**ADC Planning Consultation
Response from the Historic Buildings Adviser**

Application Number	CL/5/12/L and CL/4/12/
Address	172 The Street, Clapham
Description	Alterations and extension to form garage
Case Officer	Peter Cleveland
Site Visit	14 March 2012

PROPOSED GROUND FLOOR PLAN  
AND ELEVATIONS scale 1:50

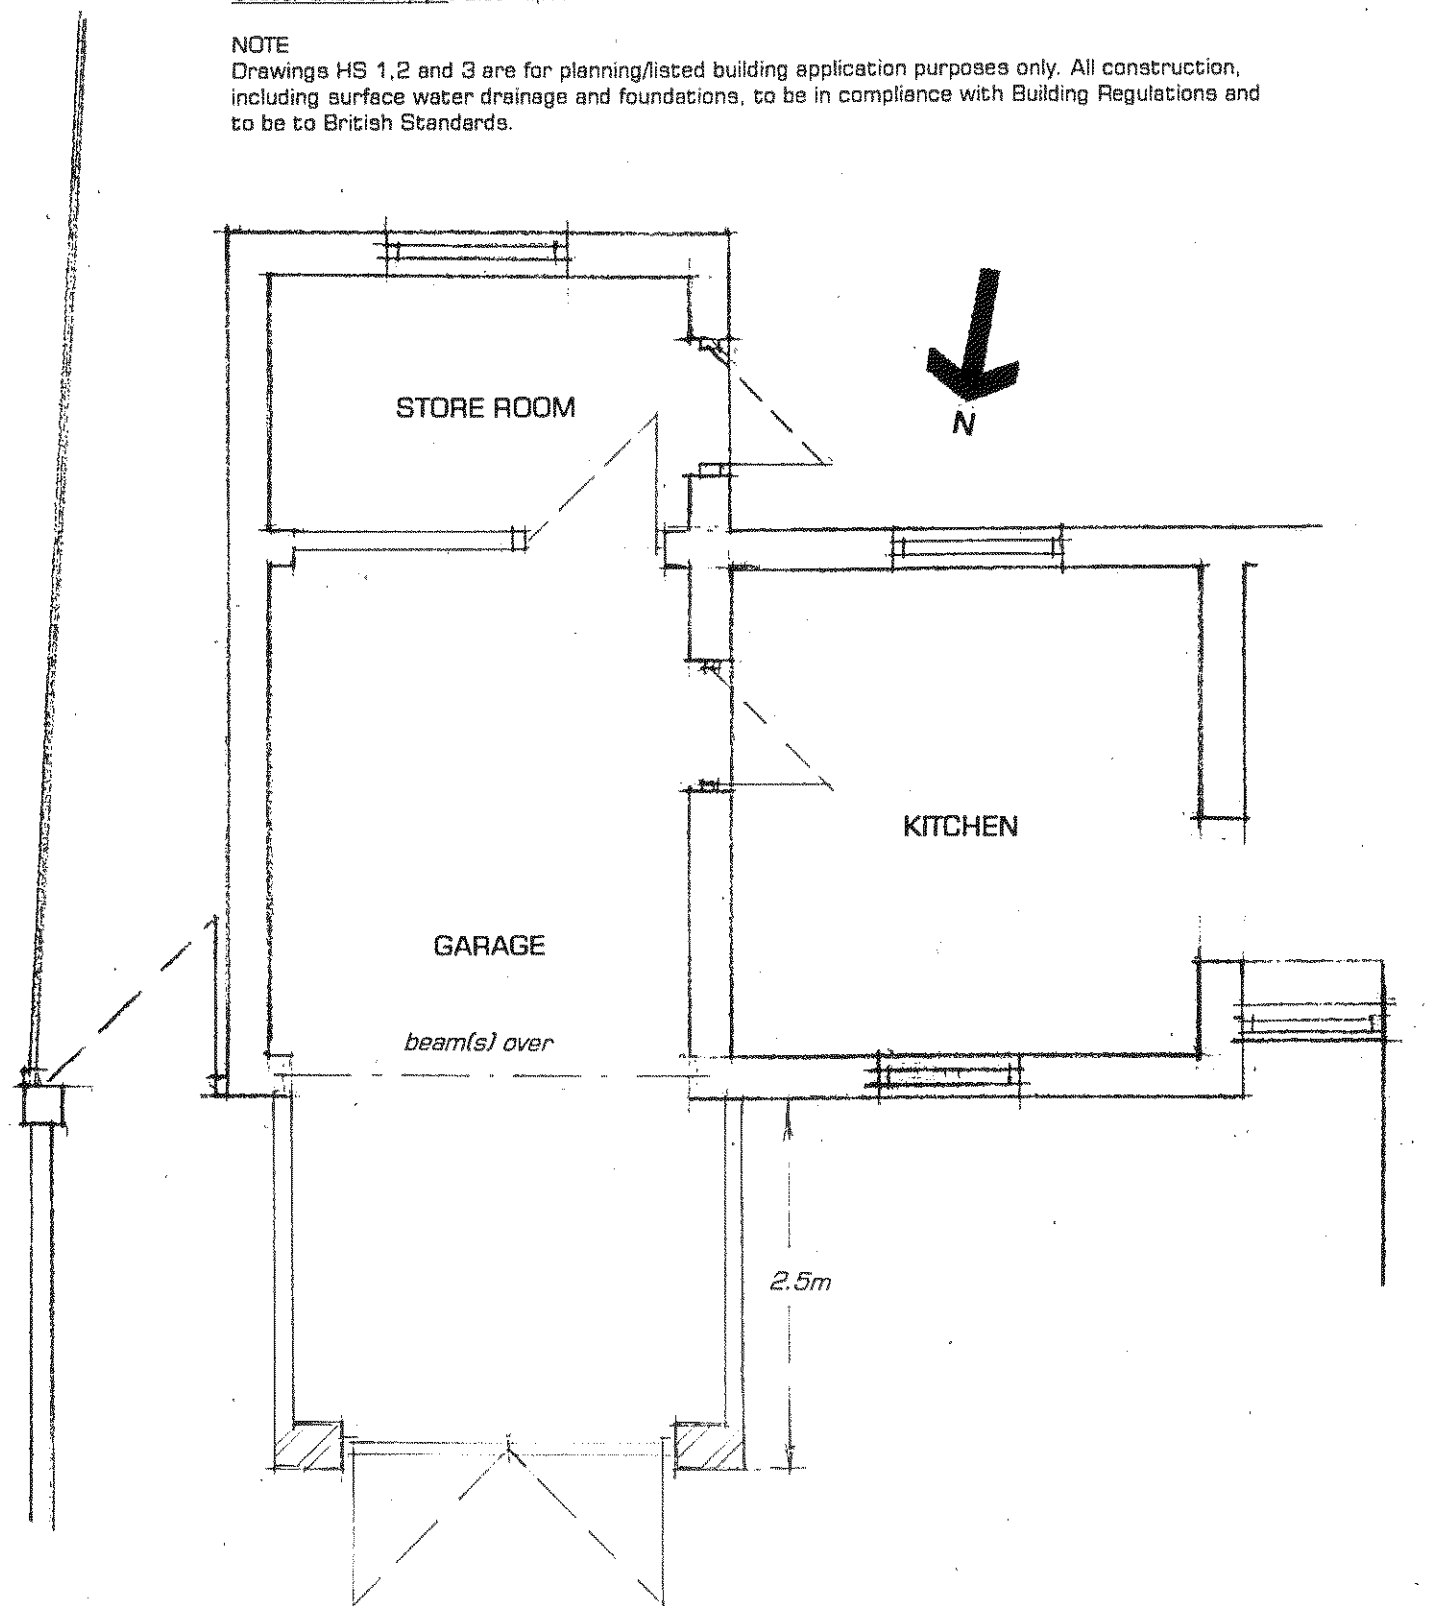
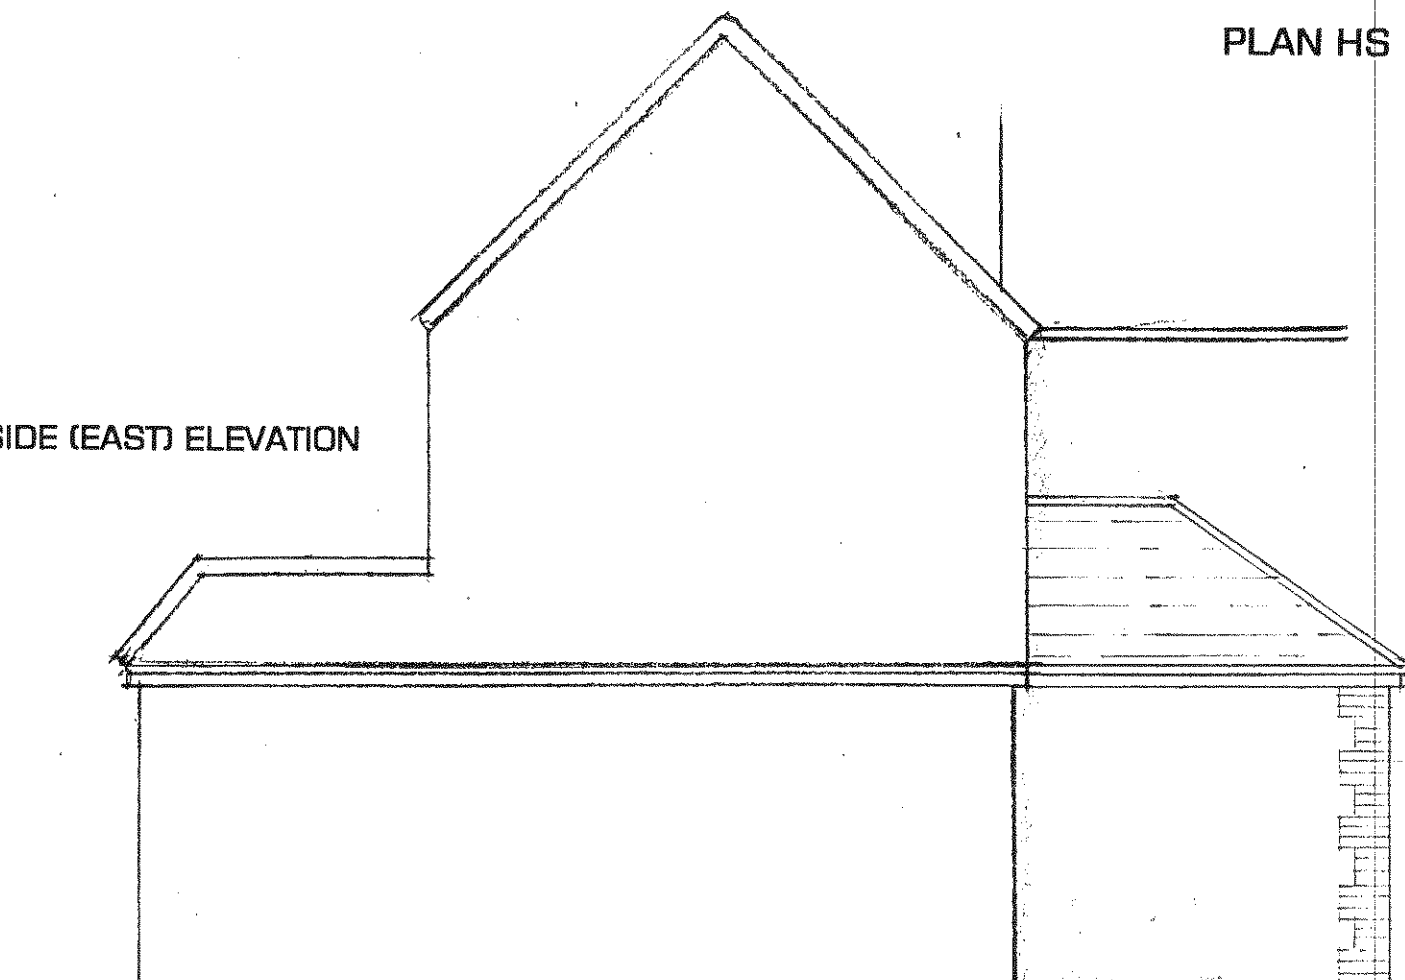
The proposed single storey addition to the front of this building is problematic on a number of levels. Its design is particularly harmful as it does not harmonize well with the existing addition and therefore looks incongruous. The new building appears merely 'attached' in this respect when it should really read as being integral with the extension and sit comfortably within its siting. As such it would be considered a distraction to the appreciation of the listed building. Para 178 of English Heritage guidance for PPS5 is quite clear about such design requirements:

Related to this, is the scope of the proposal which is also an issue as the listed building (and its plan) would begin to sprawl within the site. Single storey extensions to both the south and north would confuse the simple relationship of the two principal building elements. This would result in an overly complex group which is detrimental to the simple form of the listed building, but also its setting. This is not acceptable. Para 121 of English Heritage guidance for PPS5 comments on design and setting:
